Consultation Response from KC, Conservation & Design
2022/92236 Field House, 15 Wellington Street, Dewsbury, WF13 1BQ

Discharge of conditions 3 (detailed drawings), 4 (additional storey), 5 (materials), 6 (residential waste), 7 (A3 use waste), 9 (swift nesting), 14 (ventilation), 15 (noise assessment) and 19 (air quality) of previous permission 2019/92962 for erection of additional storey and conversion of building to provide 23 self-contained apartments and A3 use in basement and part of ground floor (Listed Building within a Conservation Area)

Date Responded: 26.6.2023
Responding Officer: Sue Brooks
Responding Ref:

0242

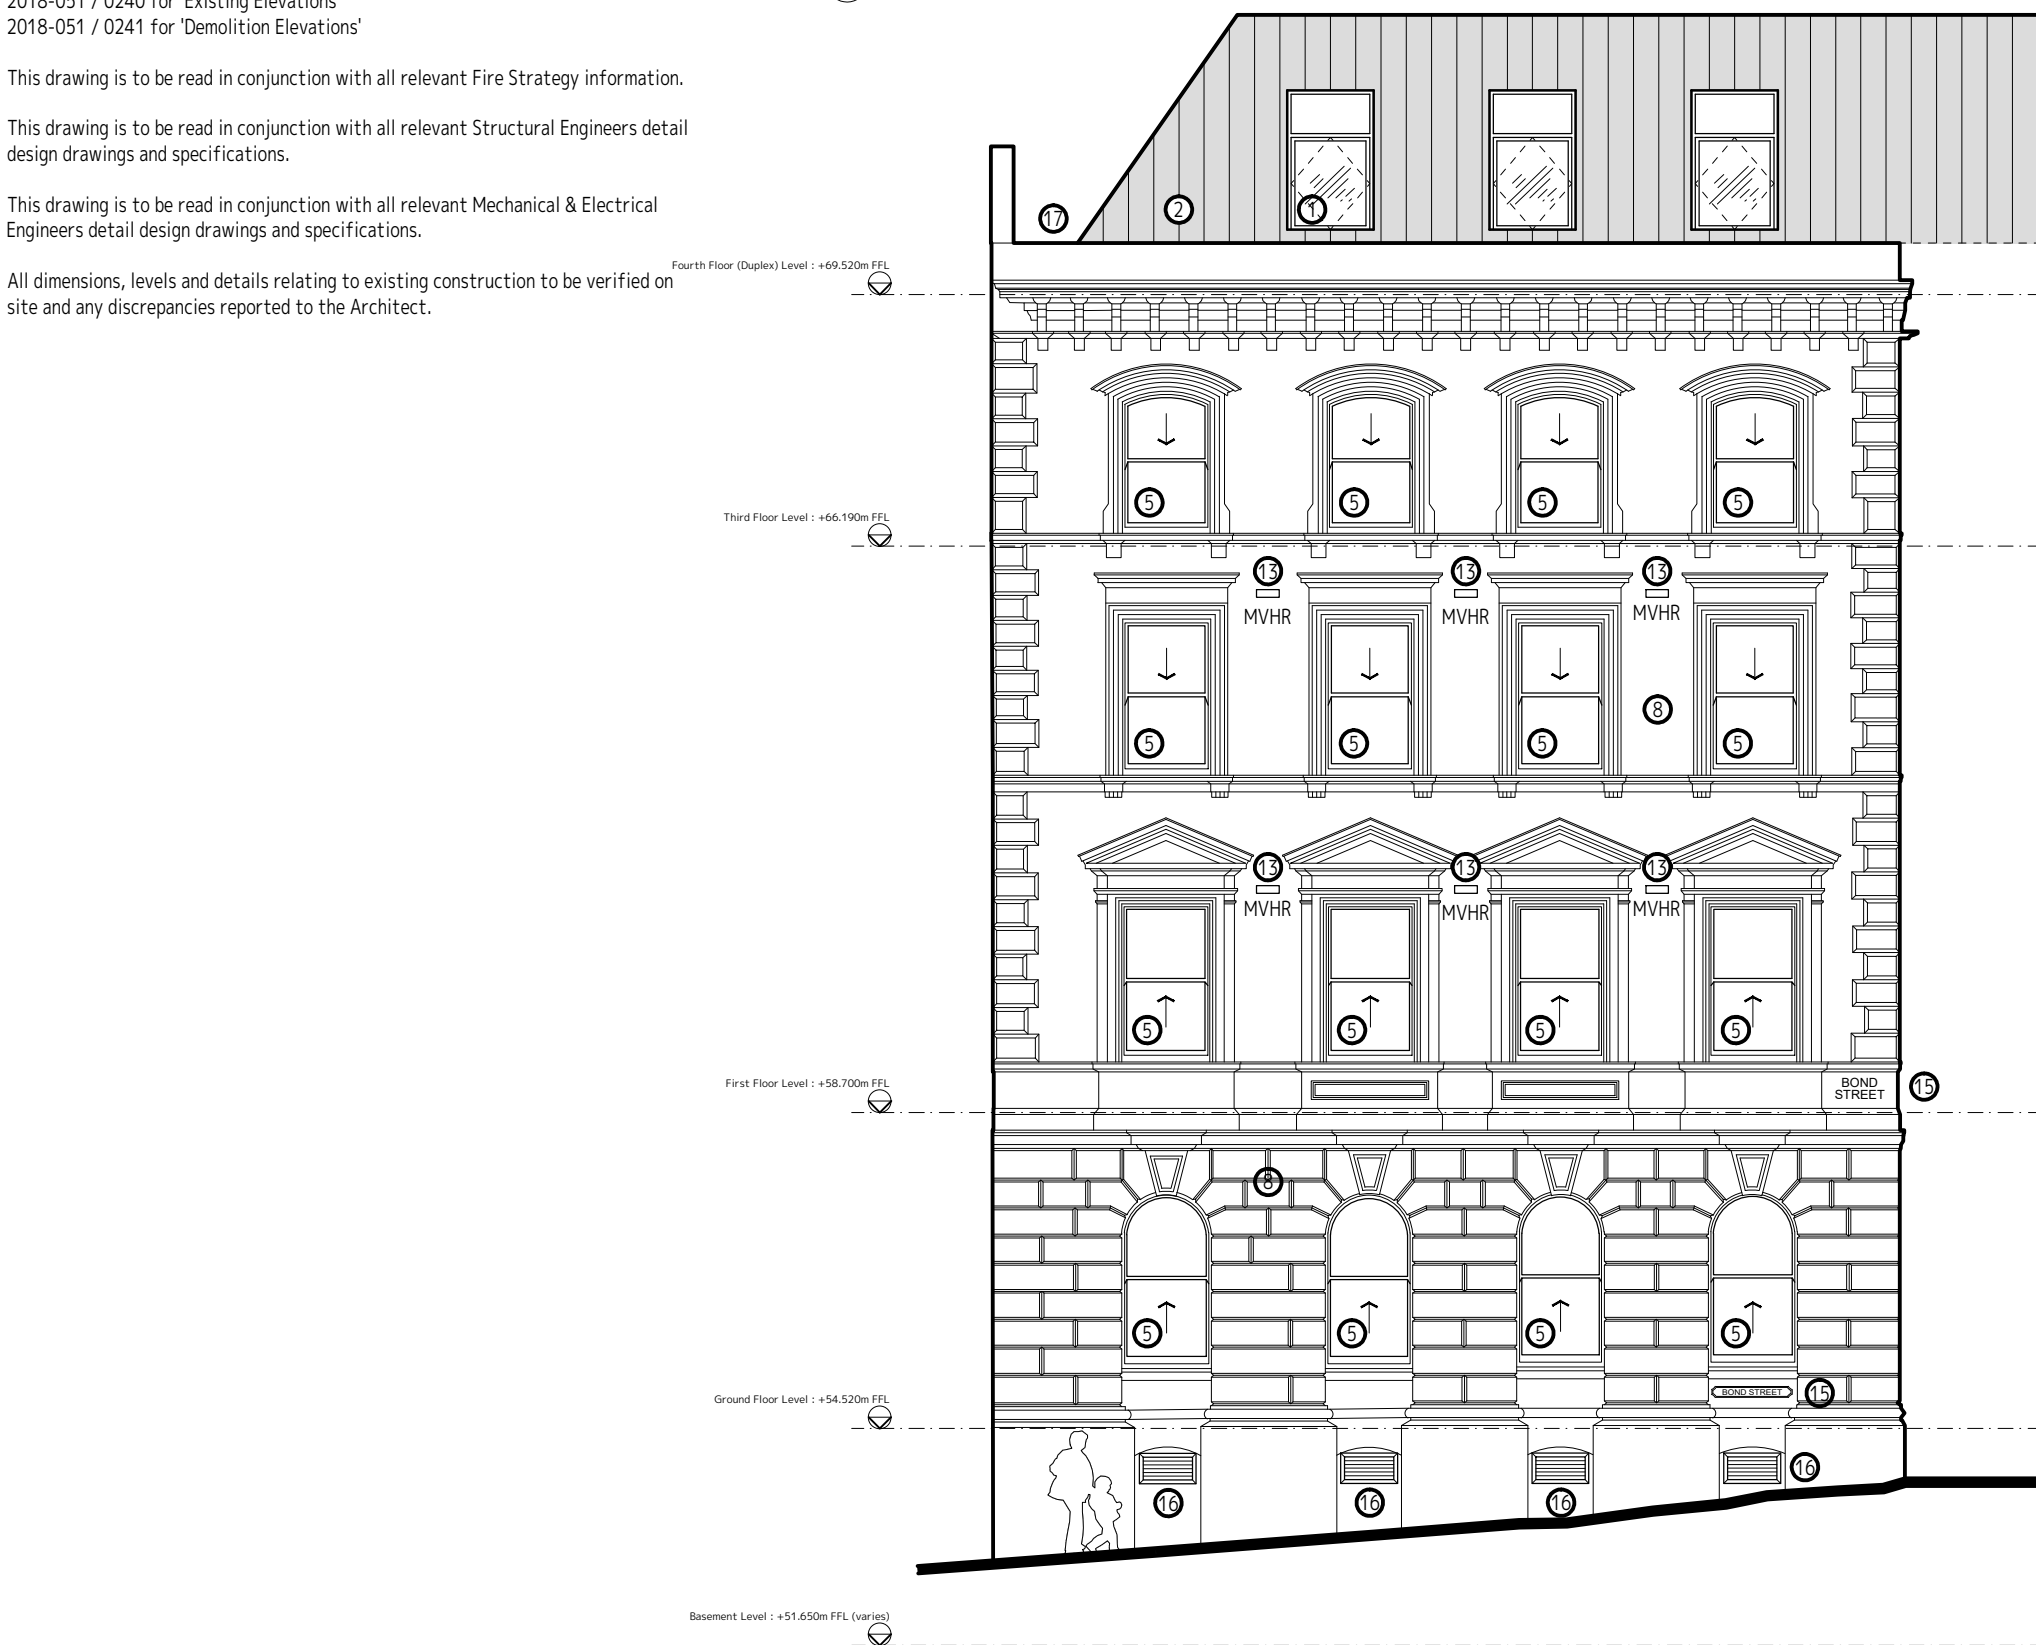
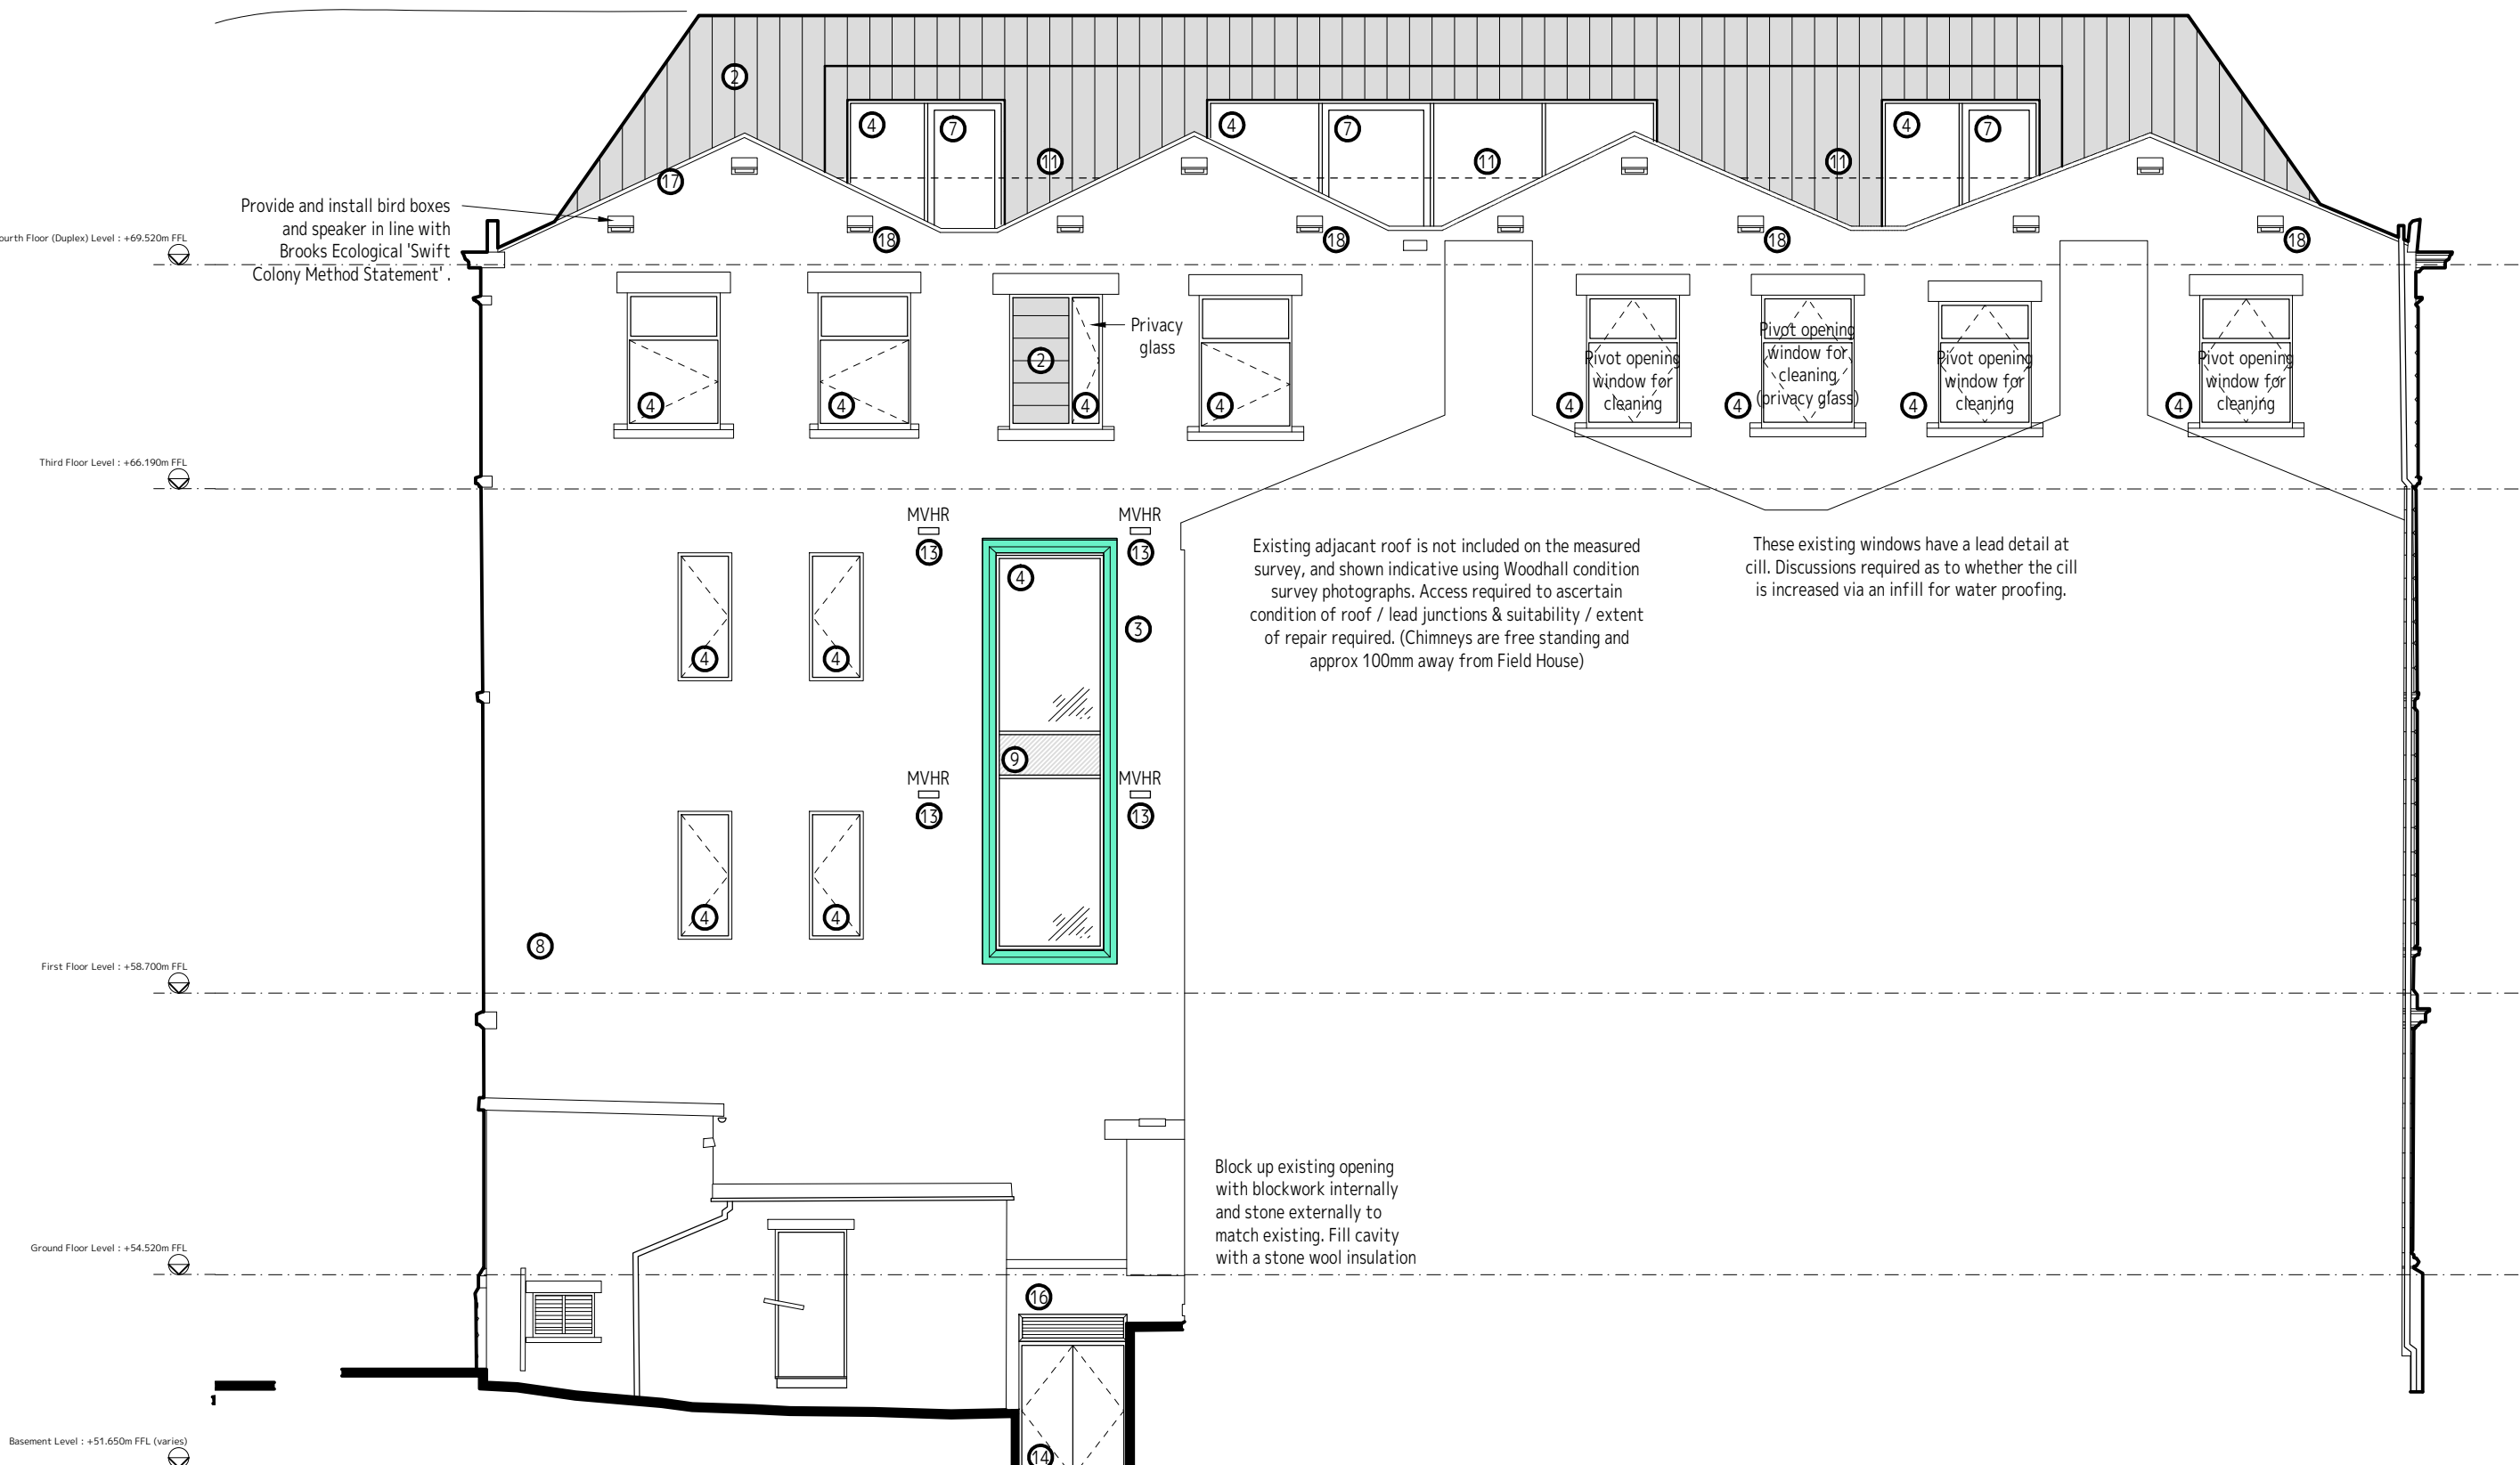
- The application proposes like for like replacement windows, however, the windows shown on the proposed drawings are one over one sashes. Most of the existing windows on elevation 3 and two of the curved windows on elevation 2 are two over two sashes with narrow central glazing bars. This needs to be amended.

- Elevation drawing 2018-051/0242C proposes aluminium framed windows on elevation 4. This contradicts the general drawing annotation that states that all new windows are timber framed. This needs to be justified or amended, with the configuration of the large side hung windows amended to reduce the visual impact of the opening lights.

- The proposed paint colour for all windows is RAL7021 black grey. The surrounding buildings within the context and setting of Field House and within the conservation area have white or

cream painted window frames. Painting these frames black will change the emphasis of the windows and they will appear more recessed. We would recommend that these are painted white or off white to complement the surrounding character.

- Proposed mansard windows are central pivot windows with fixed top light panel. We accept central pivot windows on the mansard roof slope, although details need to be submitted and it is unclear why a fixed top light panel is necessary.
